Recommendation Report for Planning Permission for Works or Extension to a Dwelling

REF NO: FP/102/21/HH

LOCATION: 25 Lionel Avenue
Felpham
PO22 8LG

PROPOSAL: Single storey extension & first floor extension.

Drawing 1 / 4

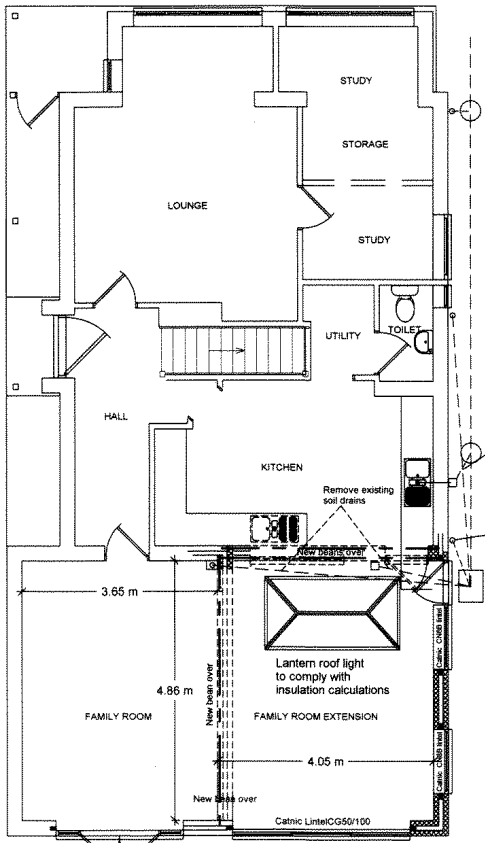
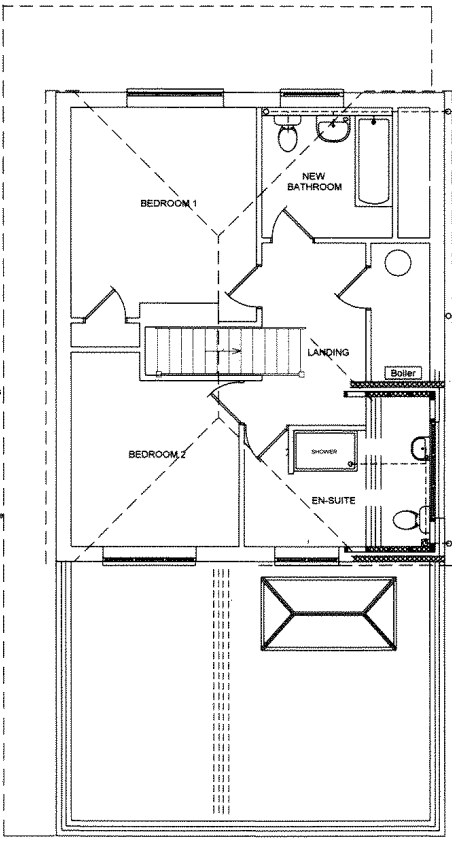
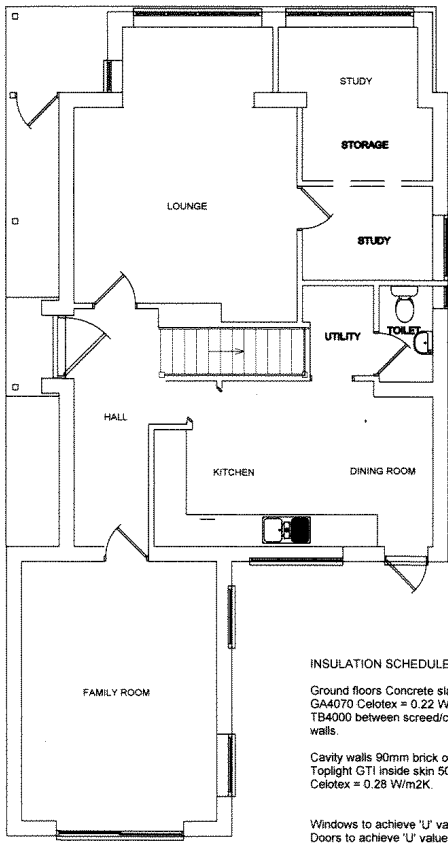
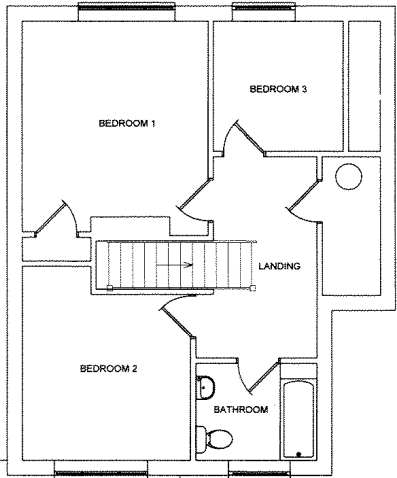
The dormer is situated to the rear end of the side roof, running along approximately half of the roof slope with a length of 3.15m. It will have a depth of 1.75m and is fairly modest in size and as such does not appear unduly dominant.

There is currently a rear extension however this only extends across half of the rear wall of the dwelling. The proposal increases the width of the extension, so that it extends along the full rear elevation. Whilst it extends to quite a large depth, this matches that which currently exists and as such, it appears well integrated and subservient with the host dwelling. Materials proposed will match existing.

The extension will have a depth of approximately 4.8m which matches the depth of an existing addition with a height at 2.9m.

A small element of the rear roof features a flat roof and this will be altered to form a slope to enable a the dormer to be constructed, which will serve a bathroom. It is not considered to give rise to any direct overlooking over the neighbouring property at No.23, with no windows to the side elevation of the property. It may provide additional views over the garden and whilst it serves a bathroom, it will be conditioned to remain obscured glazed.

There will be 2 high level windows looking east from the single storey extension, however views are not considered additional to that which are already achieved.

- 3 The first floor window to the dormer on the eastern elevation of the building shall at all times be glazed with obscured glass and only openable at a high level, at least 1.7m above finished floor level.
